**Part Of OS Parcel 5720 East Of Kyleburn And
West Of Manor Farm Main Street Wendlebury**

23/02380/F

Proposal: Change of Use of agricultural paddock to secure dog walking area and associated works (including small area of hardstanding and agricultural fencing).

LOCATION and BLOCK PLANS As Existing & As Proposed
1:2500, 1:500, 1:50 TPH August 2023
Original at A1 Drwg no. 23 / 201.02

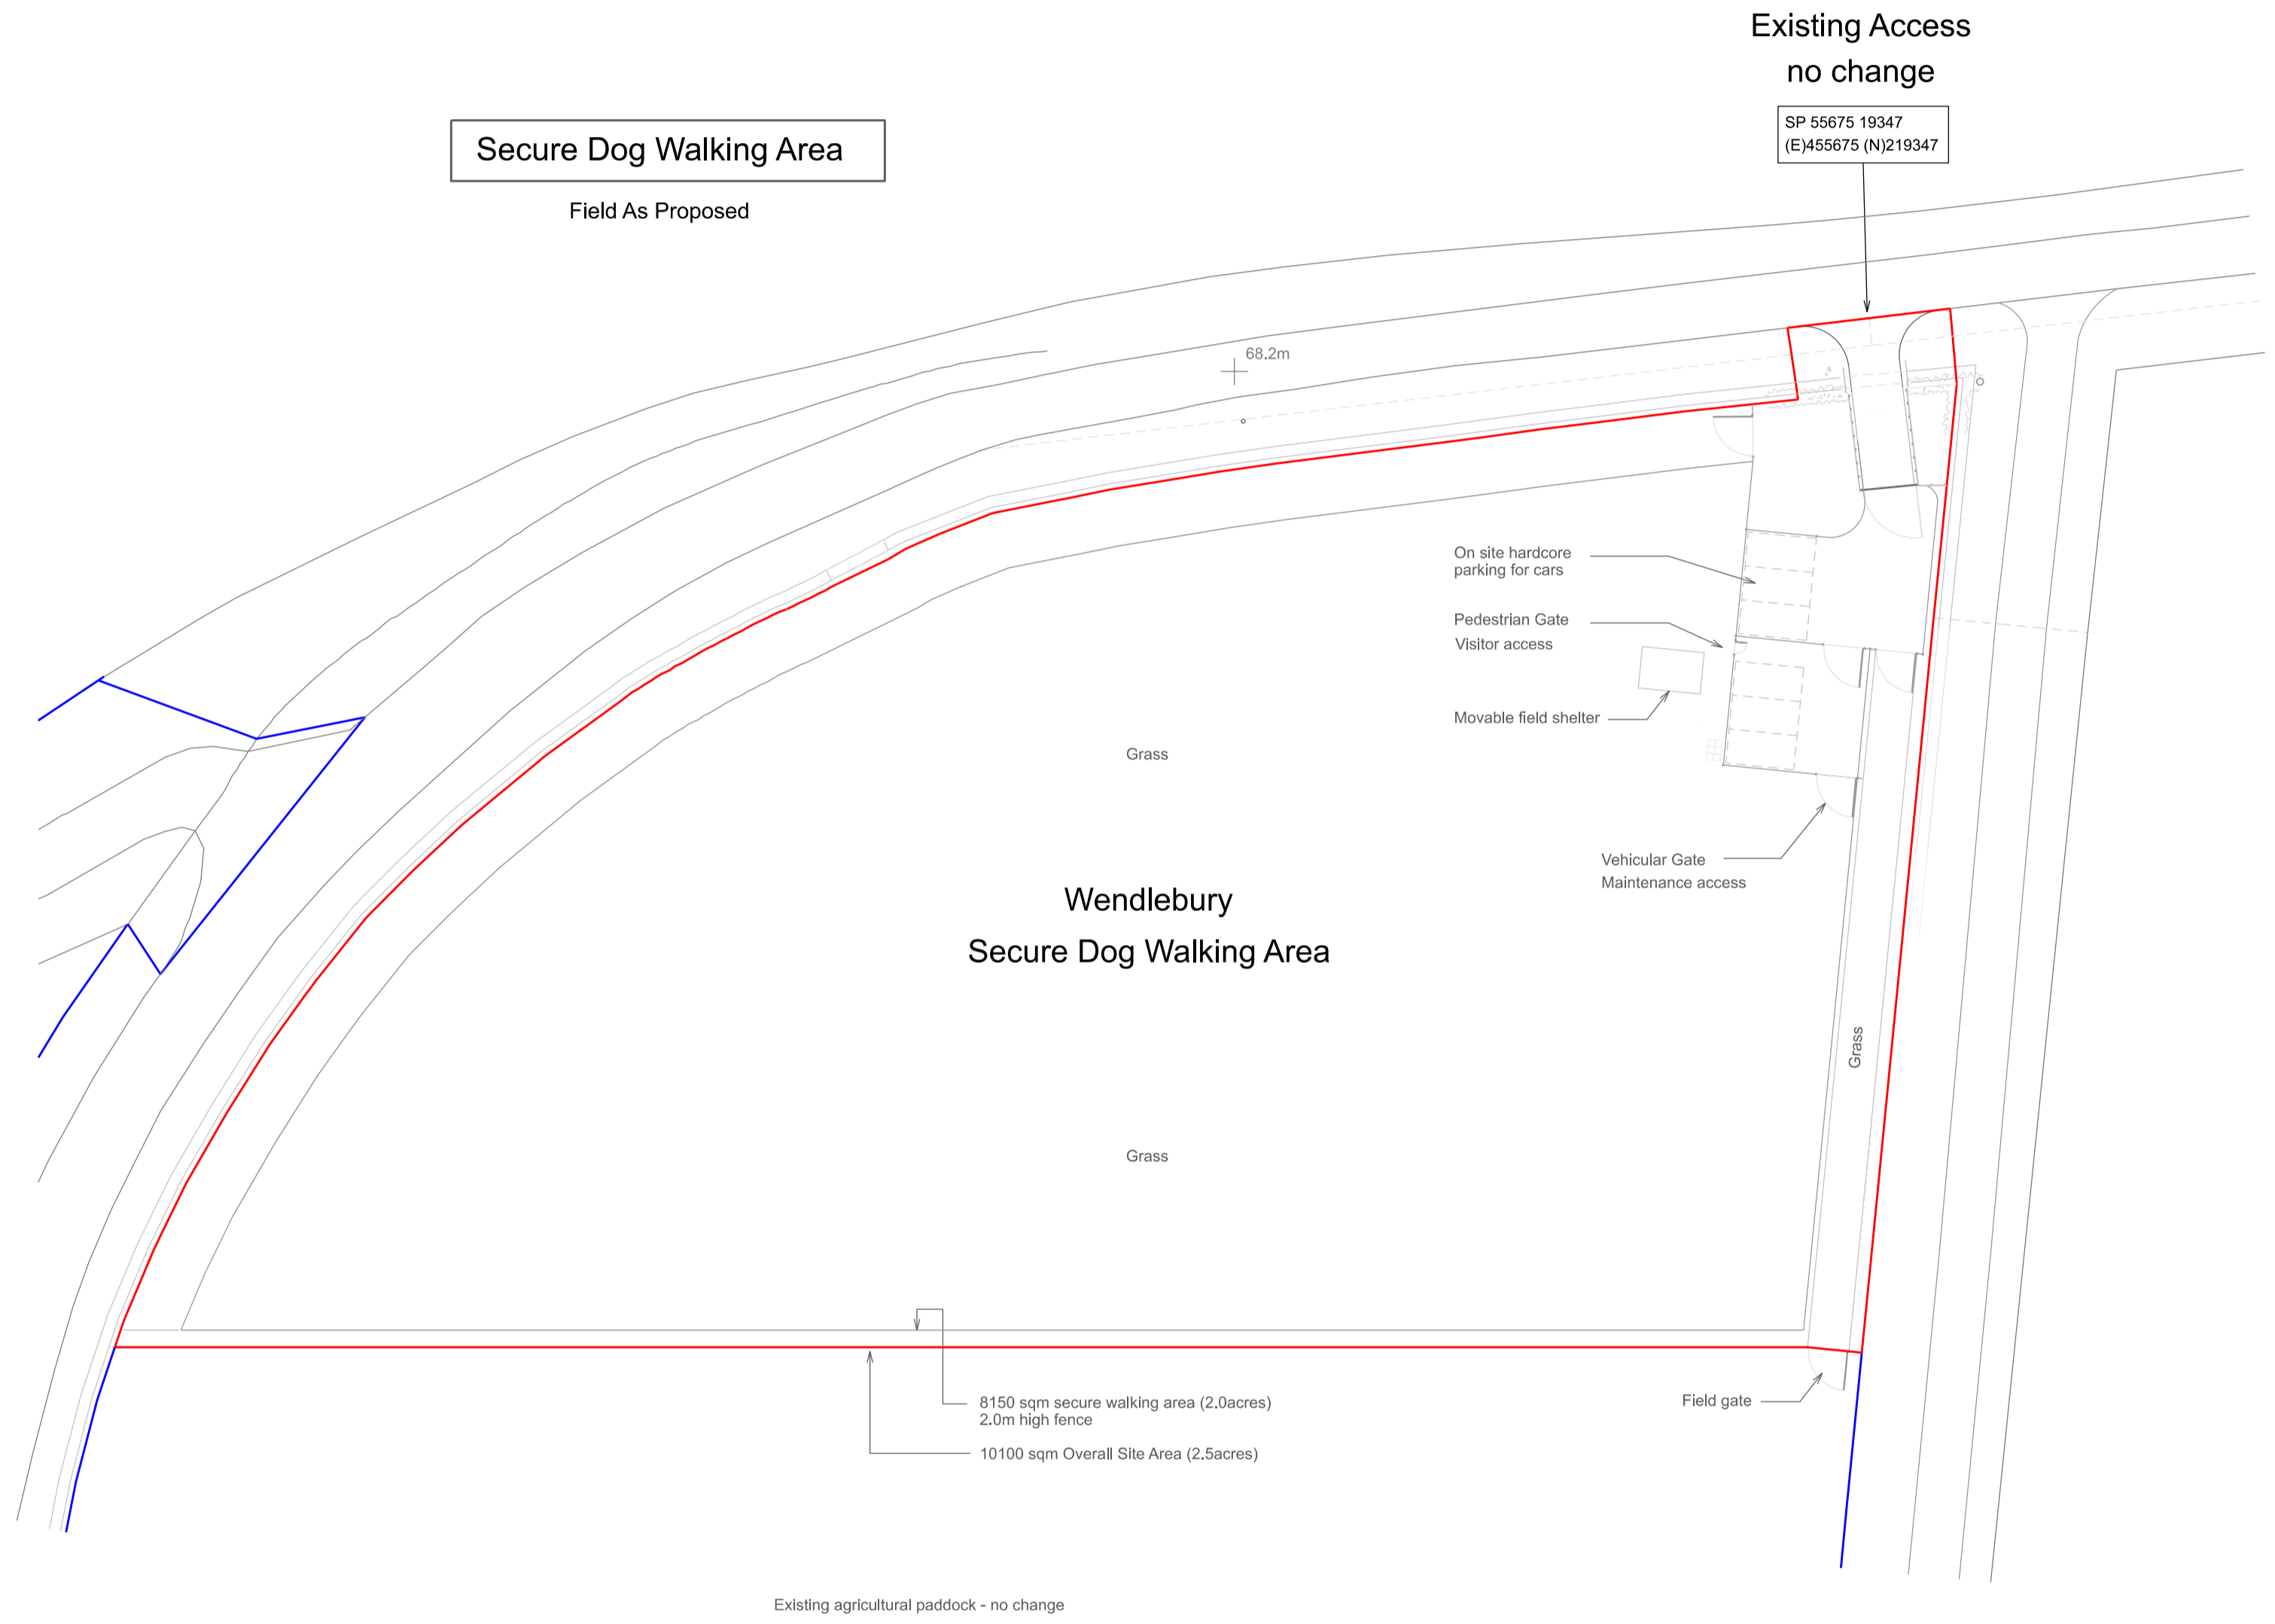
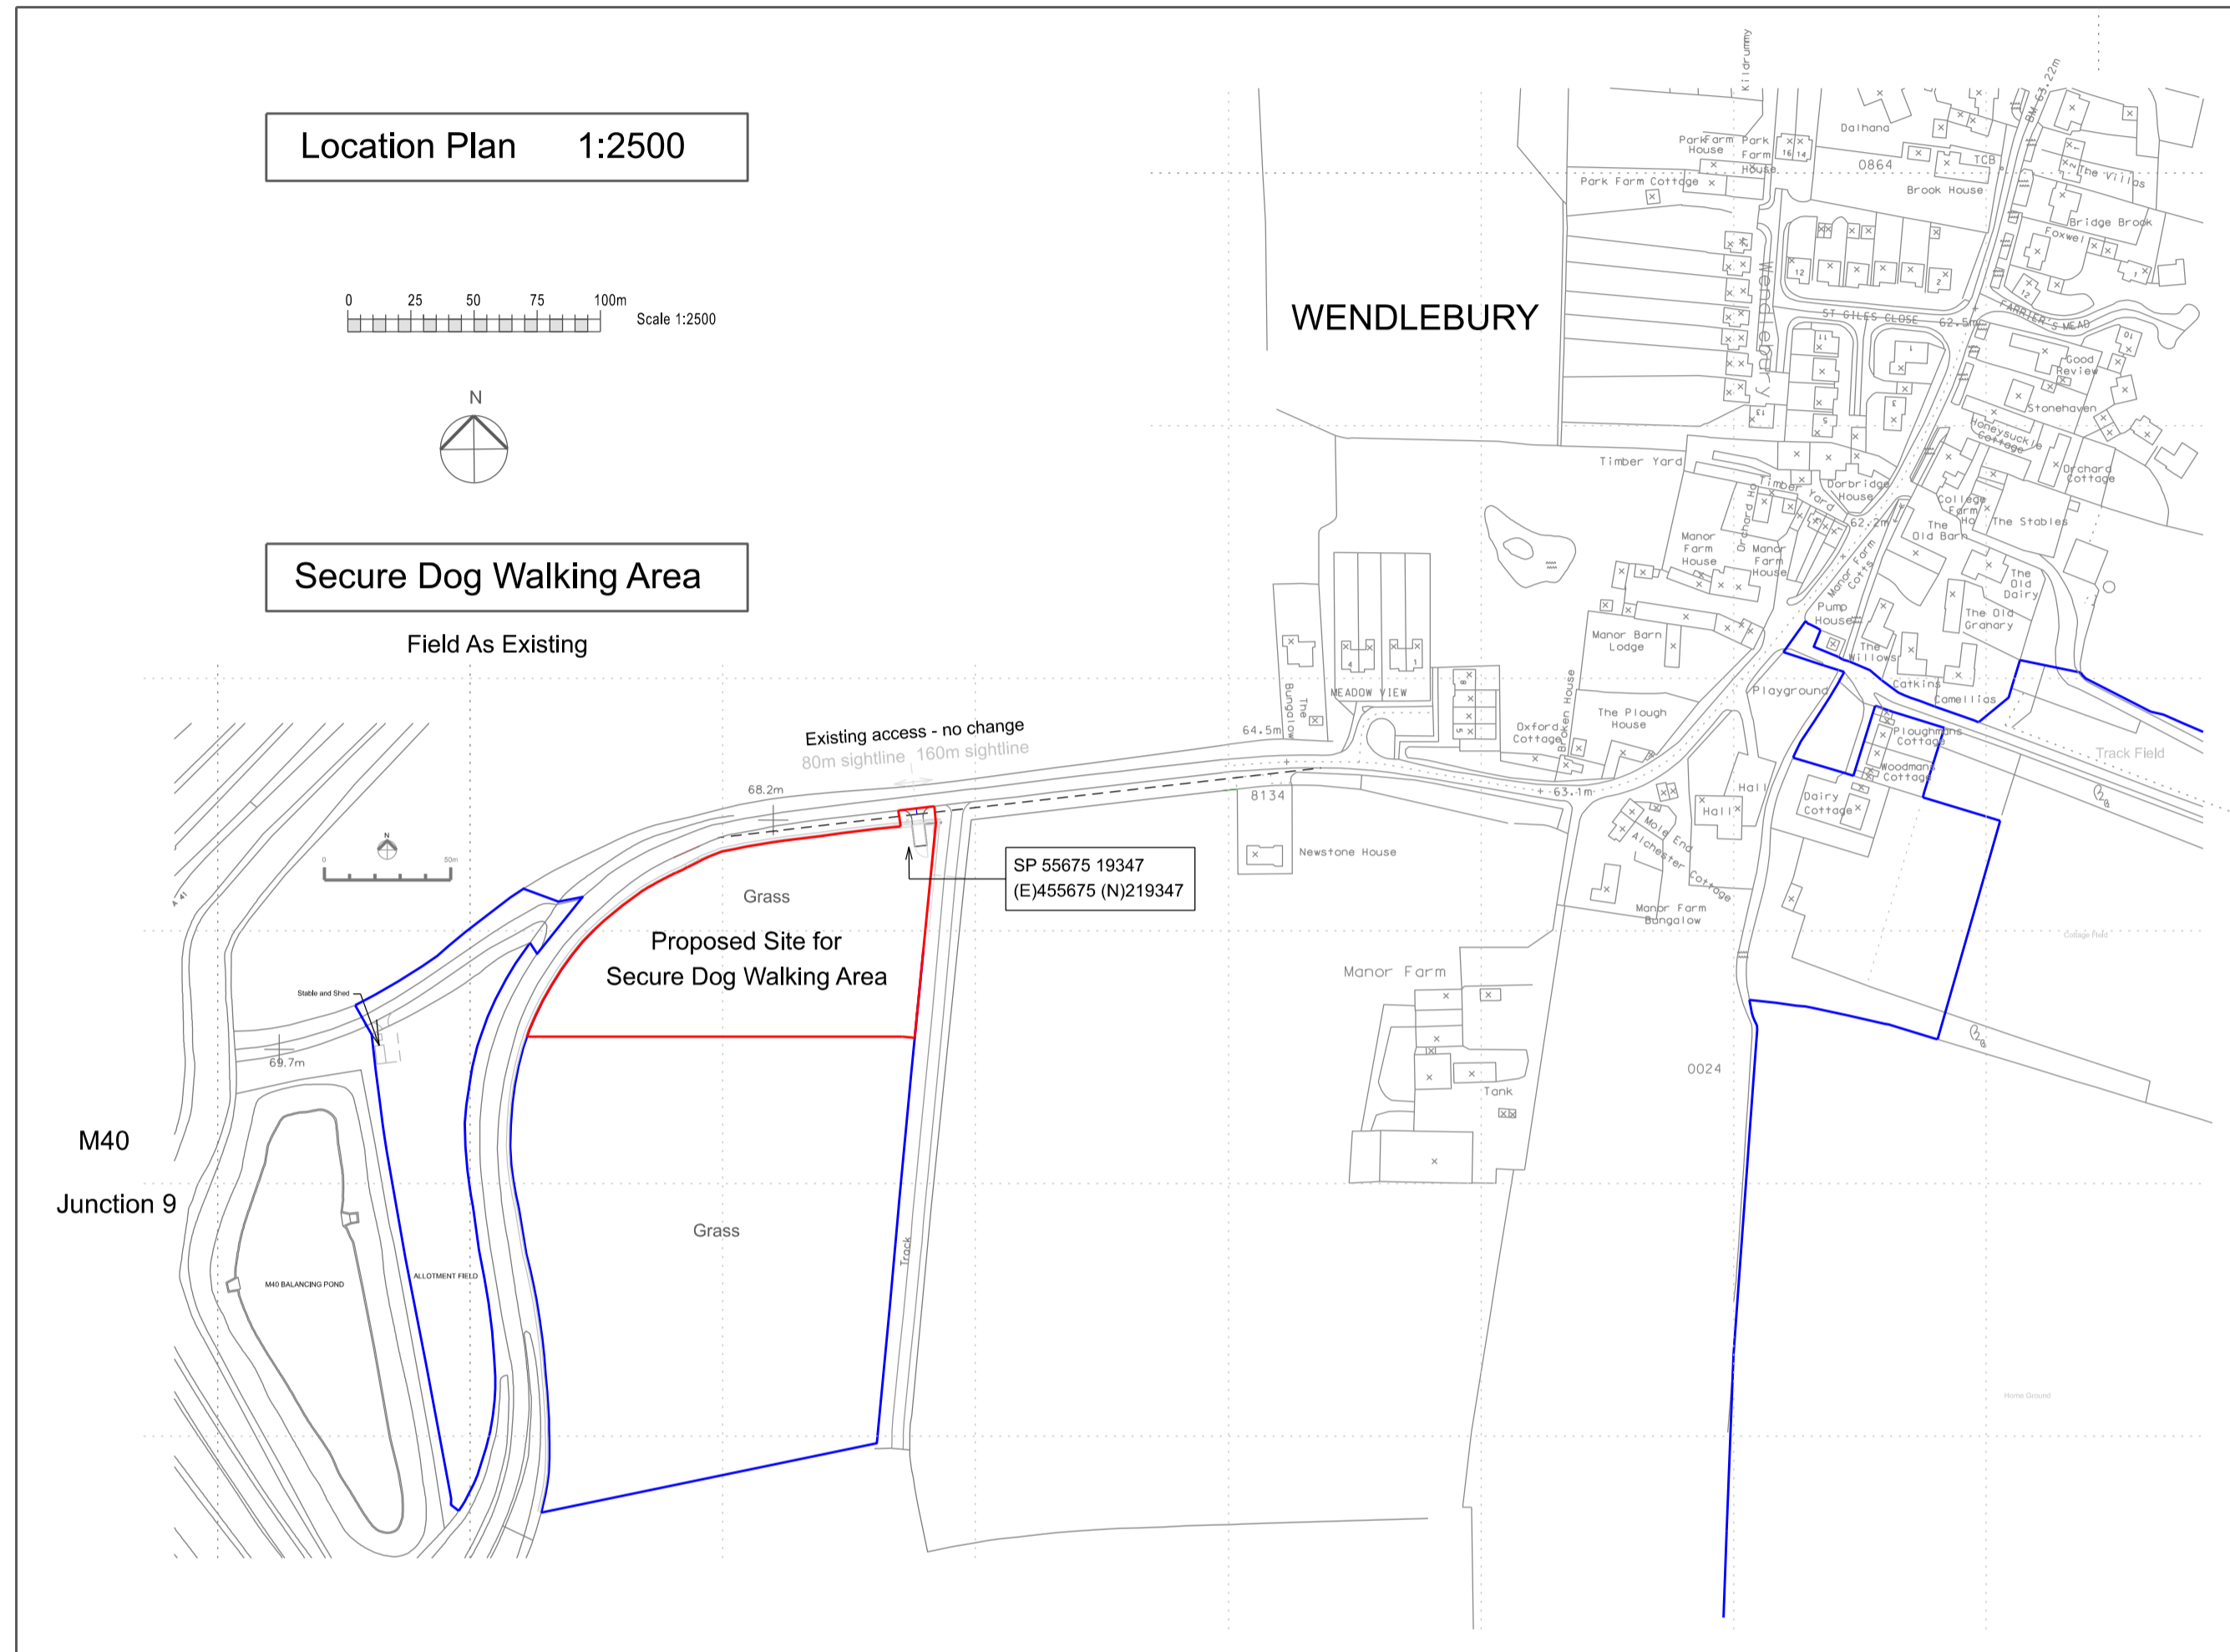
- 8.20. The site would be booked in 45 minute slots, with off-street parking provided within the site for both people making use of the field and those waiting for their slot. The applicant has indicated on the plans that no change would be made to the existing access but then go on to say in the Design and Access Statement that the existing hardstanding would be extended. However, the existing access does not appear to have been constructed in accordance with the plans approved as part of 21/04134/F as no tarmac surfacing has been laid. I therefore consider the existing access to be unauthorised.

- 8.21. The access at present consists of loose stone that is denser towards the gated entrance and becomes more sparse as it gets closer to the public highway. With more frequent use by customers, particularly during the winter months, I am concerned about this access becoming both unsightly and spreading mud out onto the public highway as vehicles exit causing safety risk.

- 8.22. I note the Local Highway Authority has raised no objection to the proposal but has requested further details of the access. Despite the applicant indicating that no change would be made, I consider that revised details are required in order to both regularise the unauthorised works and improve the existing access. Subject to this condition, I consider that the proposed development would not result in harm to highway safety, in accordance with the above Policies.

3. Notwithstanding the details hereby approved, and prior to the first use of the site as a secure dog walking area, full details of the means of access between the land and the highway, including, position, layout, construction, drainage and vision splays shall be submitted to and approved in writing by the Local Planning Authority. Thereafter, the means of access shall be constructed in full accordance with the approved details and shall be retained and maintained as
